Re: Objection to Planning Application 2026/90930 – 349 Whitehall Road, Wyke, BD12 9DP

I wish to formally object to planning application 2026/90930 relating to the demolition of the existing garage and erection of single storey side and two storey side and rear extensions with dormer windows at 349 Whitehall Road, Wyke, BD12 9DP, as detailed on the submitted plans.

Issue Purpose : Planning Application  
Client N/A  
Project N/A  
Address 349 Whitehall Road, Wyke, Bradford BD12 9DP  
Title Existing and Proposed Plans

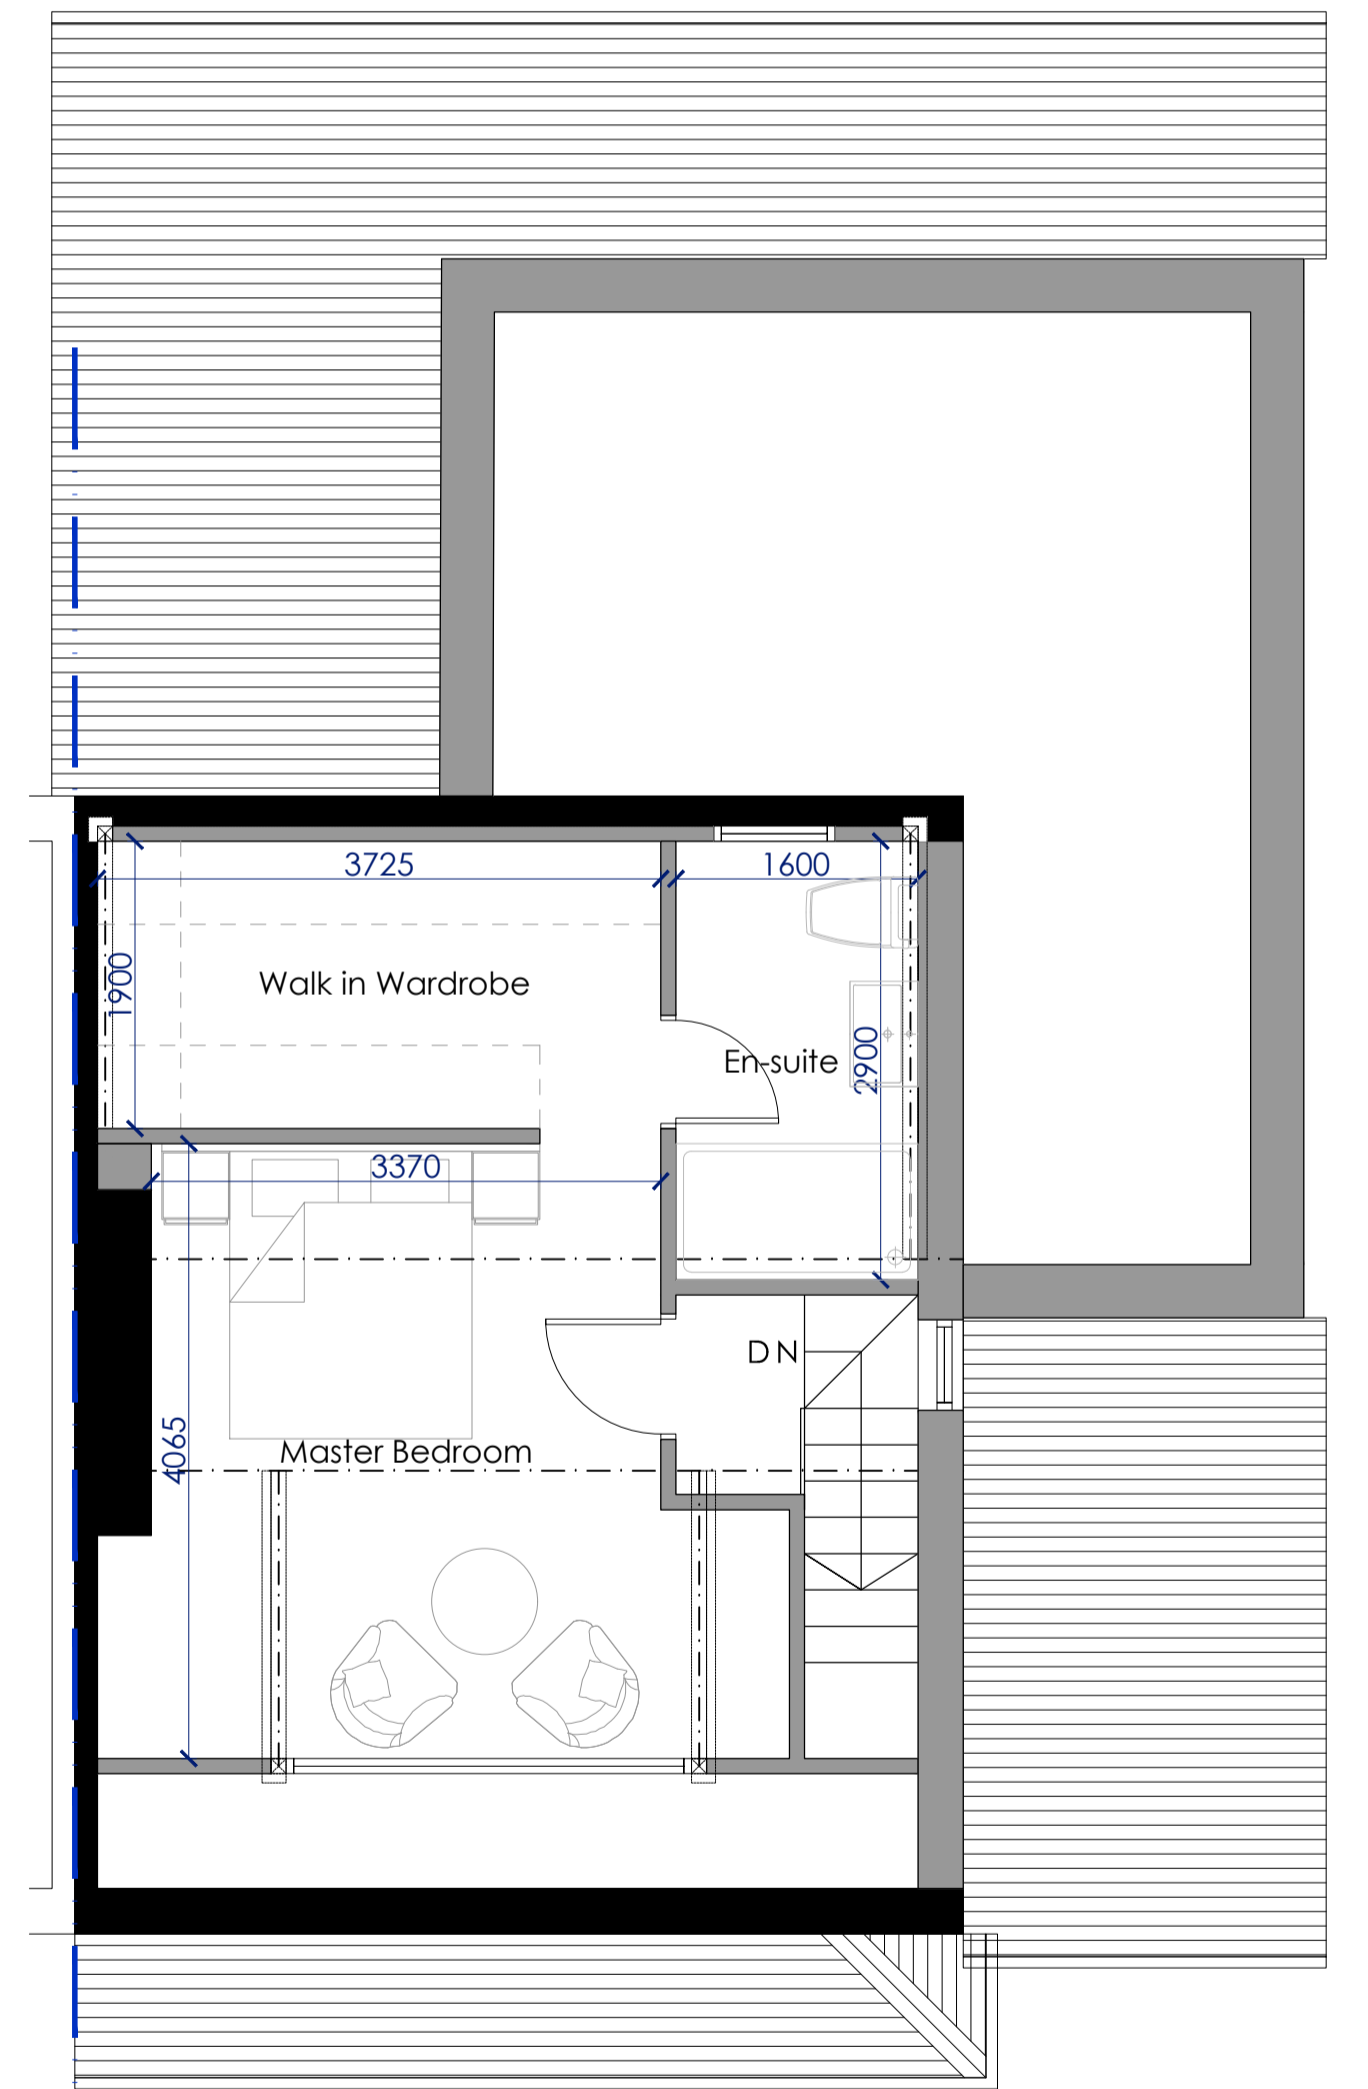
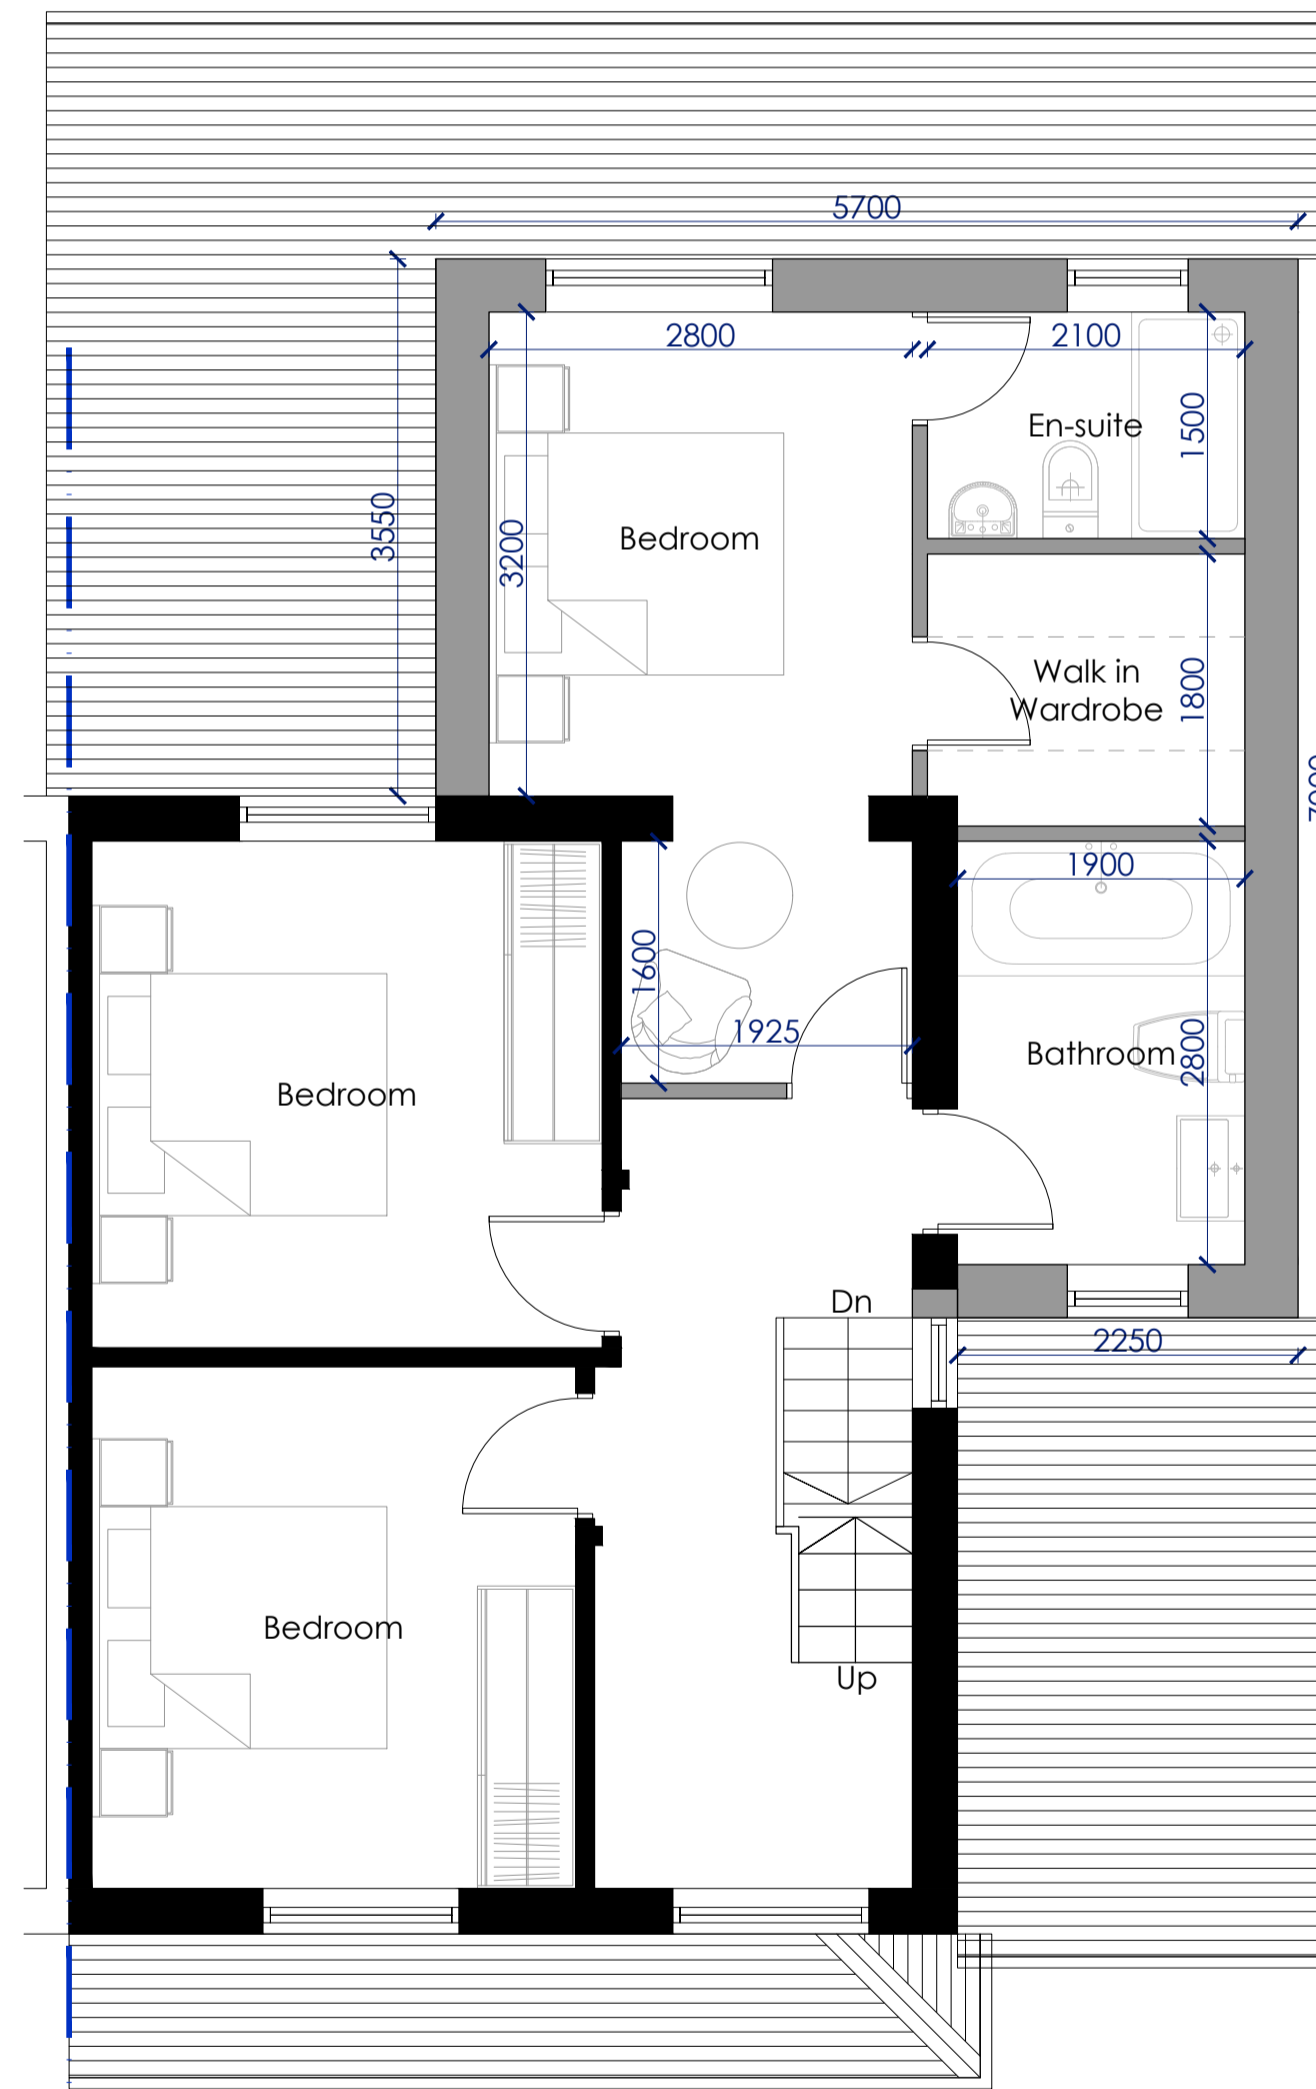
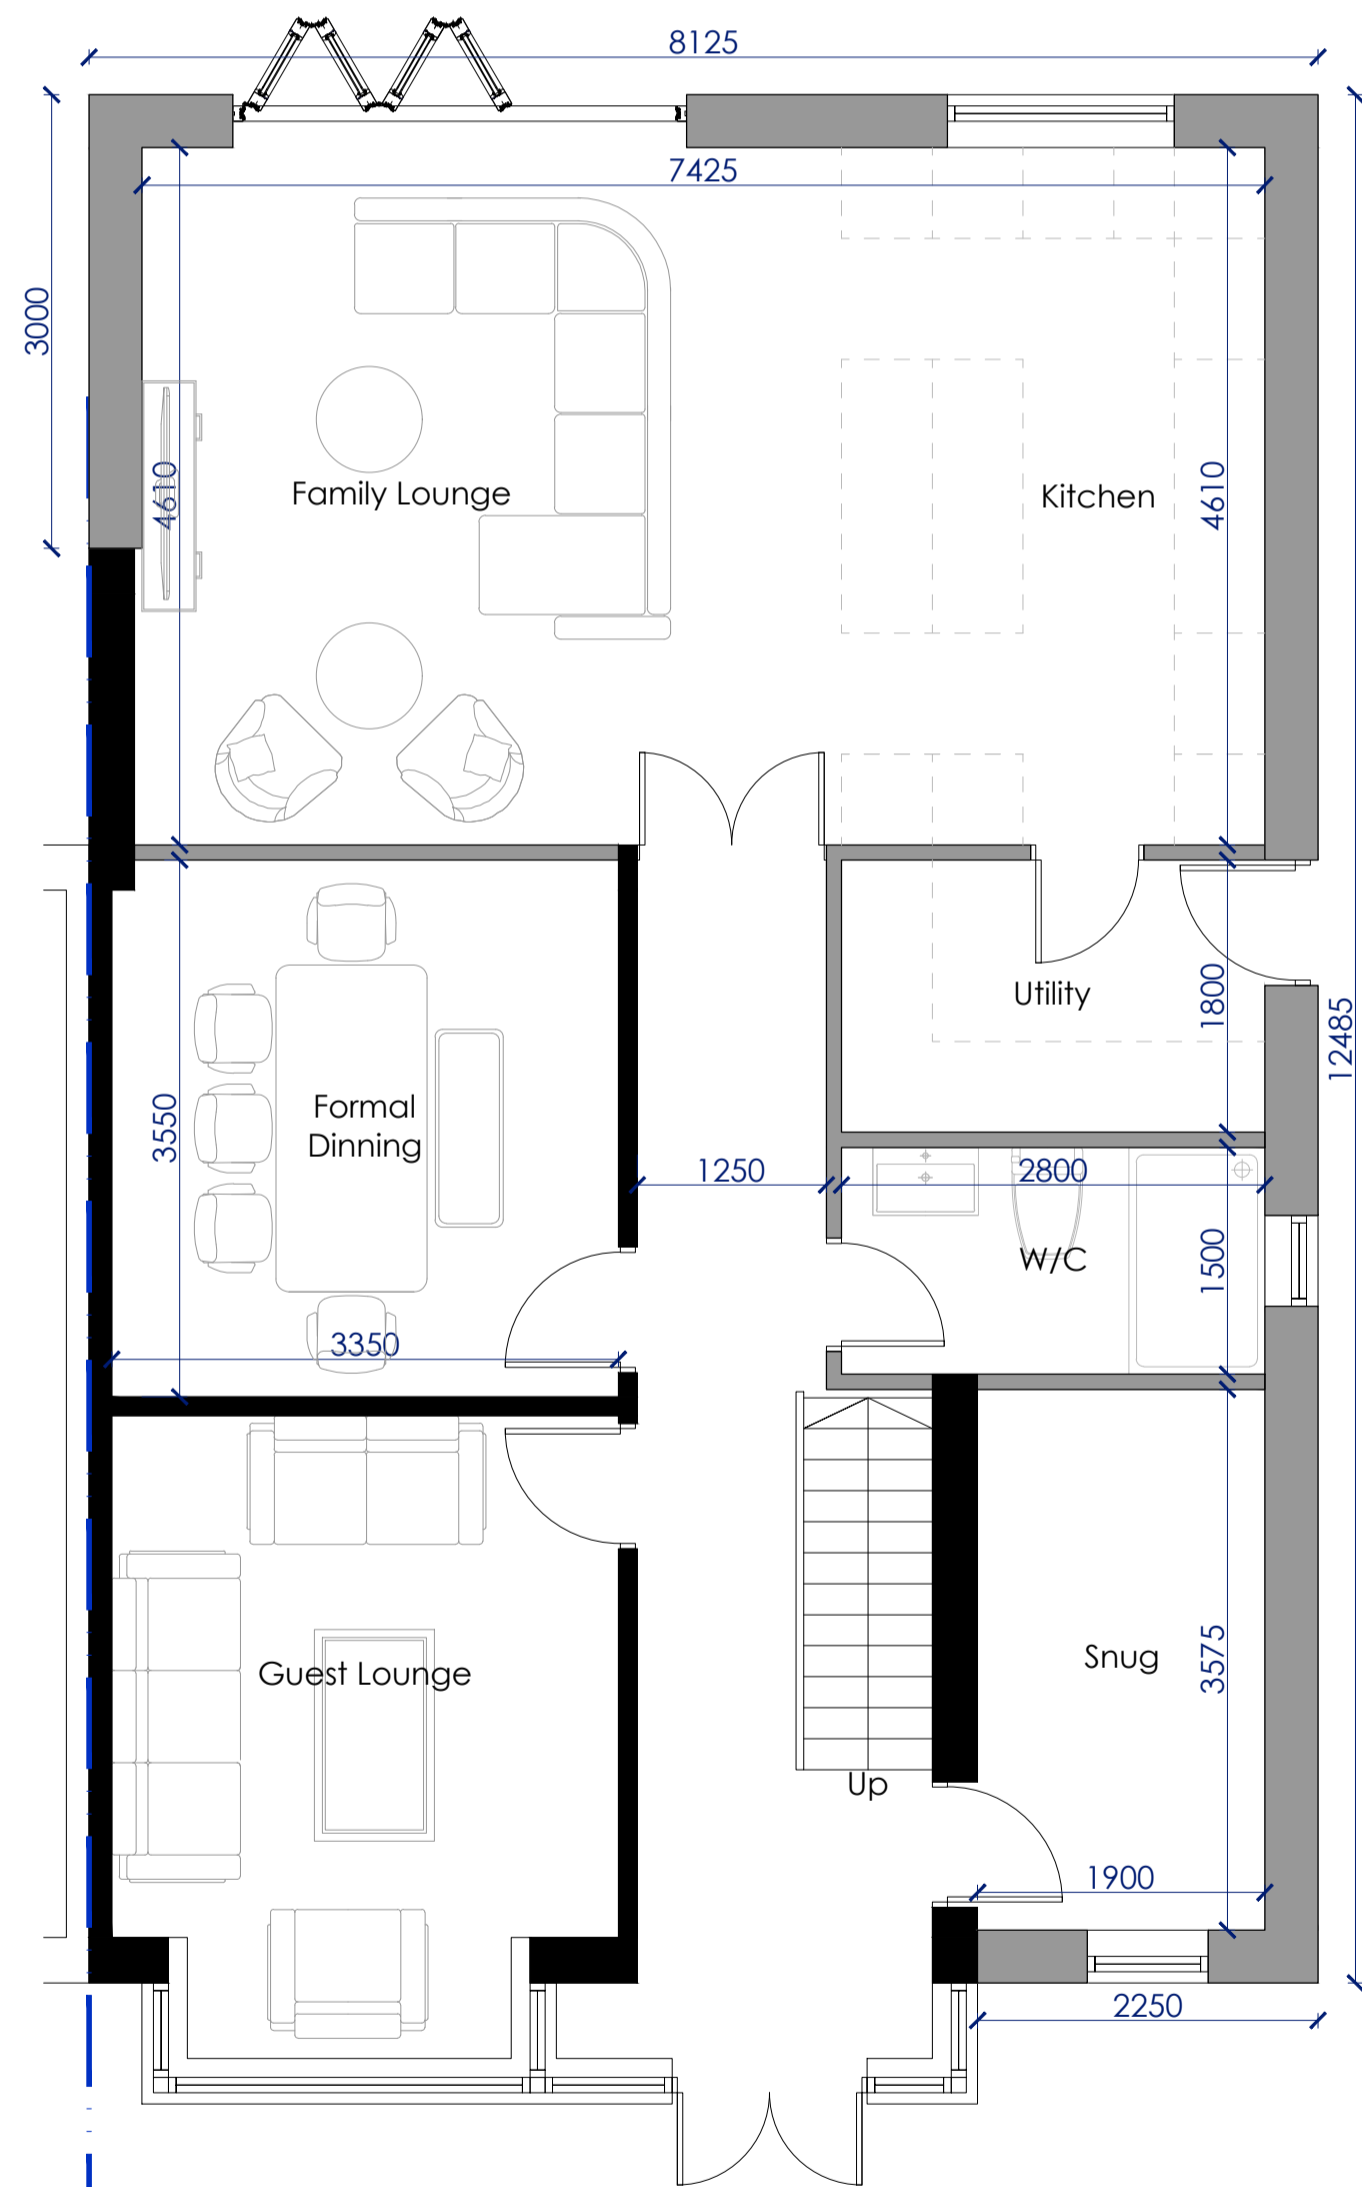
The proposed development represents an excessive and disproportionate enlargement of the existing dwelling. The submitted drawings show substantial extensions to the side and rear, together with significant loft alterations and dormer additions, resulting in a development that materially increases the scale, bulk and massing of the property.

The proposals appear to leave very limited spacing around the dwelling and result in an overly dominant form of development on what is a relatively modest plot. The combination of;

- a two-storey side extension,
- a substantial rear projection,
- a single-storey side extension,
- and a large rear dormer,

creates a cramped appearance that is out of keeping with the spacing and character of neighbouring properties along Whitehall Road.
